Application for Removal or Variation of a Condition following Grant of Planning Permission or Listed Building Consent

Erection of single storey side extension to provide additional living accomodation

P23/01570/HH

Change to roof pitch to proposed side and rear extension

site: SIDE ELEVATION - PROPOSED
(As seen from No.7 NT)

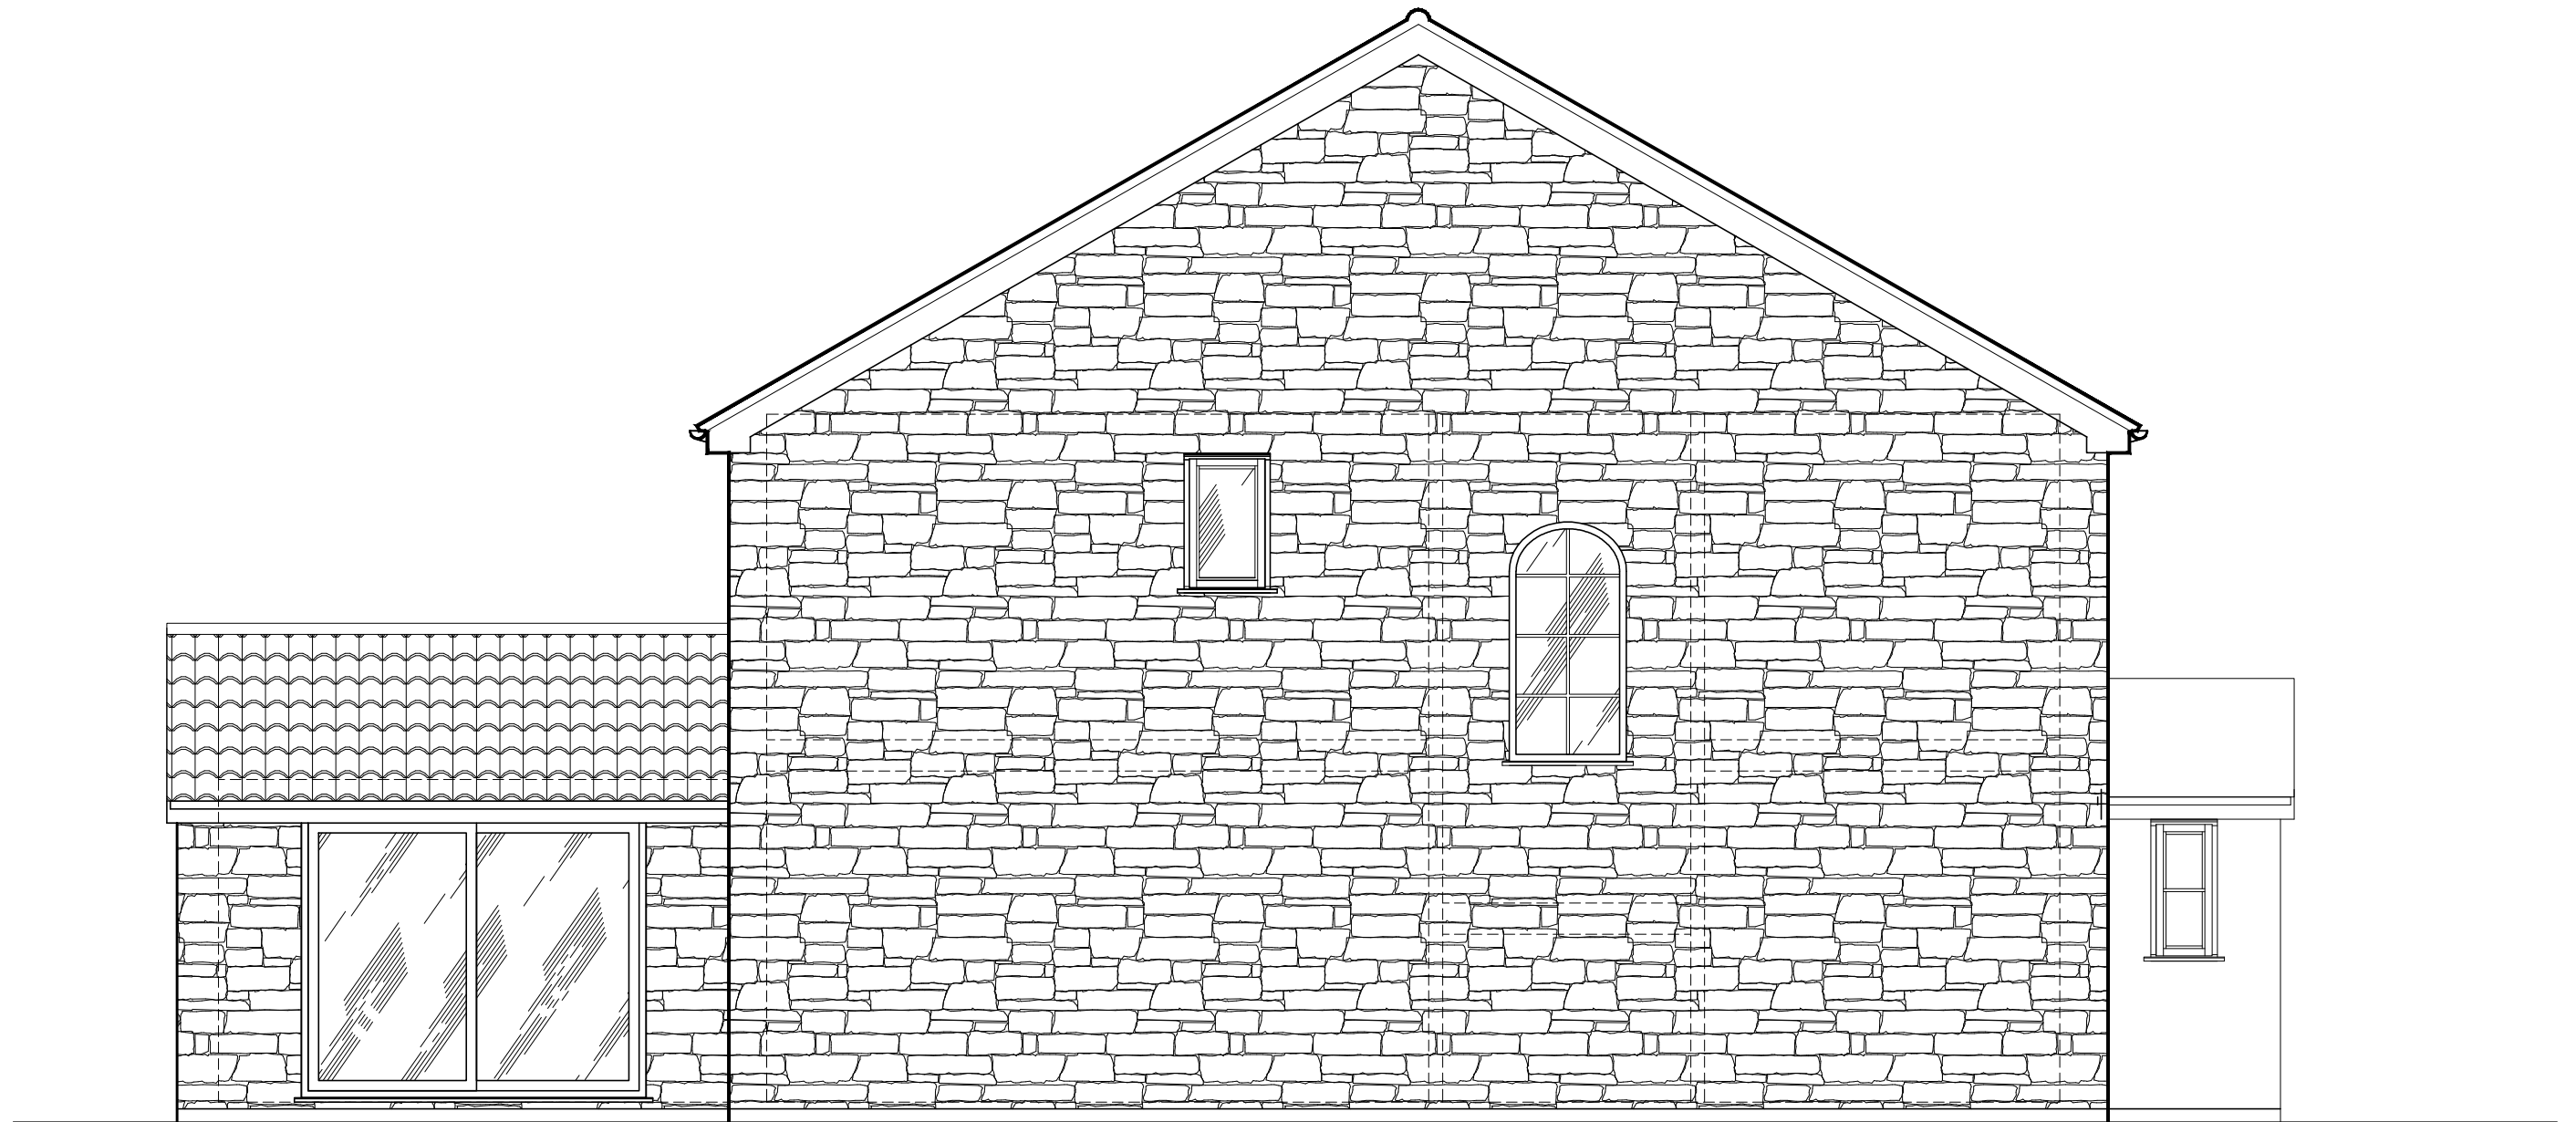
Proposed new side extension roof to follow existing garge roof line upto the end of existing house and the to continue with an equal pitched roof from the rear of the existing house to the gable end of the proposed extension with reduction of rooflights from 3 to 2 (In accordance with the attached revised plans)
